Comments about Planning Permission Application number 2021/62/90172/W

Erection of a two storey extension to side of 11 Olney Street, Slaithwaite, Huddersfield, HD7 5EG

Dwg ref: 11OS-P2/P03 a : Scale 1:100 @ A3 : December 2020 : As Proposed Elevations

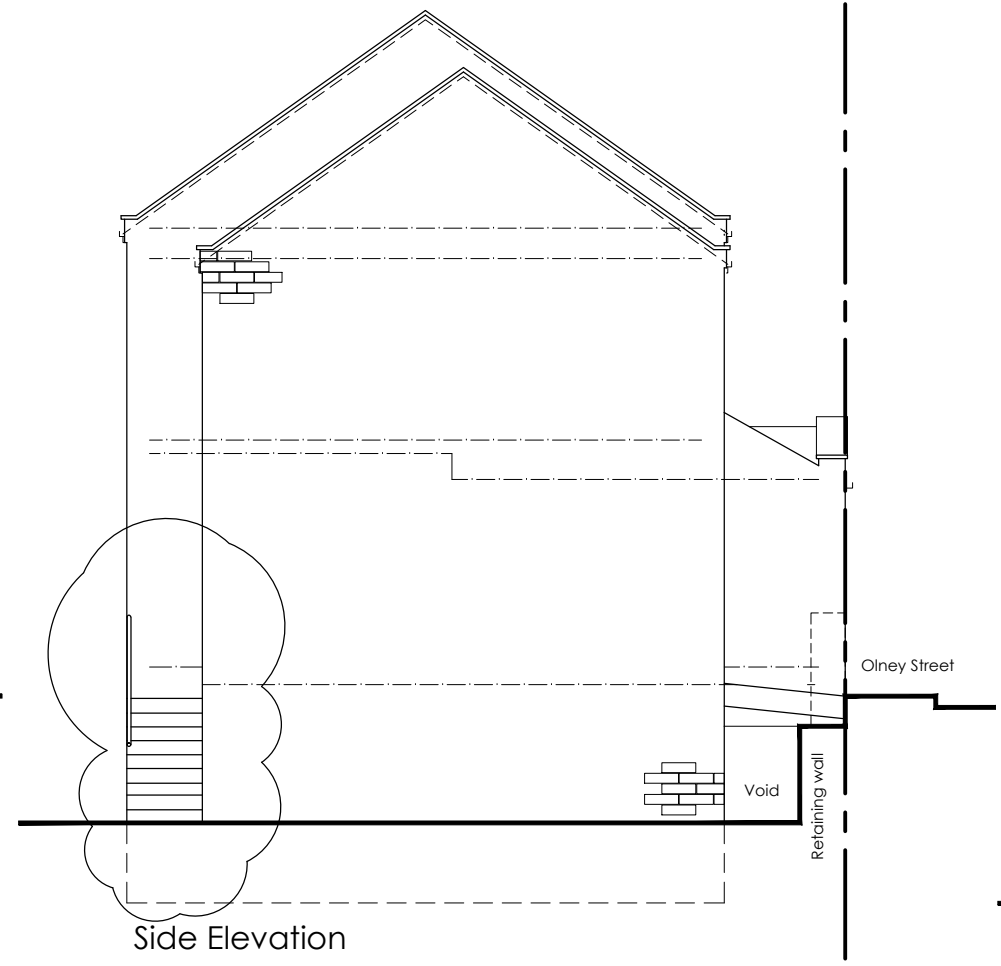
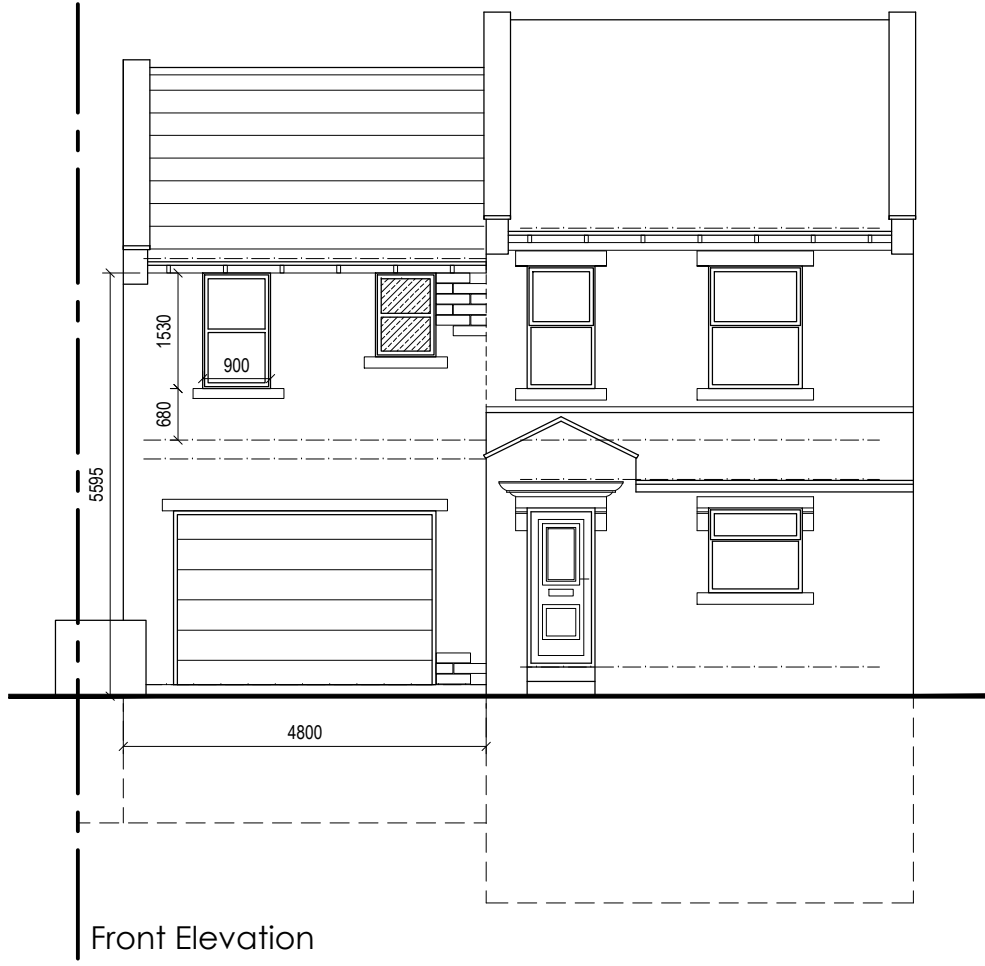
The roof covering of the proposed structure is described in the application as concrete Marley modern tiles to match the existing.

However, the slates on the existing structure are riven / cleaved Penrhyn Heather Blue from a northern Welsh slate mine such as Cwt-y-Bugail. The only way to match the existing would be to use Penrhyn Heather Blues of the same size & gauge. Concrete tiles are much cheaper than natural slate. Matching the existing roof and indeed that of the adjacent buildings is being ignored probably due to the cost of doing it correctly.

The rear of the structure shows a Juliet balcony. This is hardly in keeping with the existing building of Edwardian style. These balconies serve no purpose or benefit over an opening window. The balcony would be better replaced with an opening window of similar style to the existing building, in a 2:1 ratio, of the same size with a sash style frame and so the lintels and cills line through.

The proposed extension lines up with the existing original front wall of the house and is to be made from coursed natural york stone to match the existing. However, the gutter line, corbels, eaves, and ridge stop lower than that of the existing structure. It also means the window cills and lintels do not line through with the existing. It makes the windows look too small and out of character. The extension looks like it is stuck on to the end of the existing structure and done on the cheap, so as not to have to line up all the building elements. Why not do it right? It might cost slightly more, but it would look much better and in keeping with the existing structure.

The extension would look much better if the ridge and eaves, front and rear walls, all lined up with the existing building. The springer stones and tabling stones moved to the end of the building, and walling stone, gutter and corbels all lined thorough to match. The windows should also match the existing structure in size and alignment. The extension would then look like it was always part of the Edwardian structure. The current proposal makes it look like a bodged attempt at matching the style.

Why have a rear external staircase? It will look like an eyesore stuck to the back of the extension. Use the existing internal one or form a new internal one with the rear of the extension lining up with the rear of the existing building.
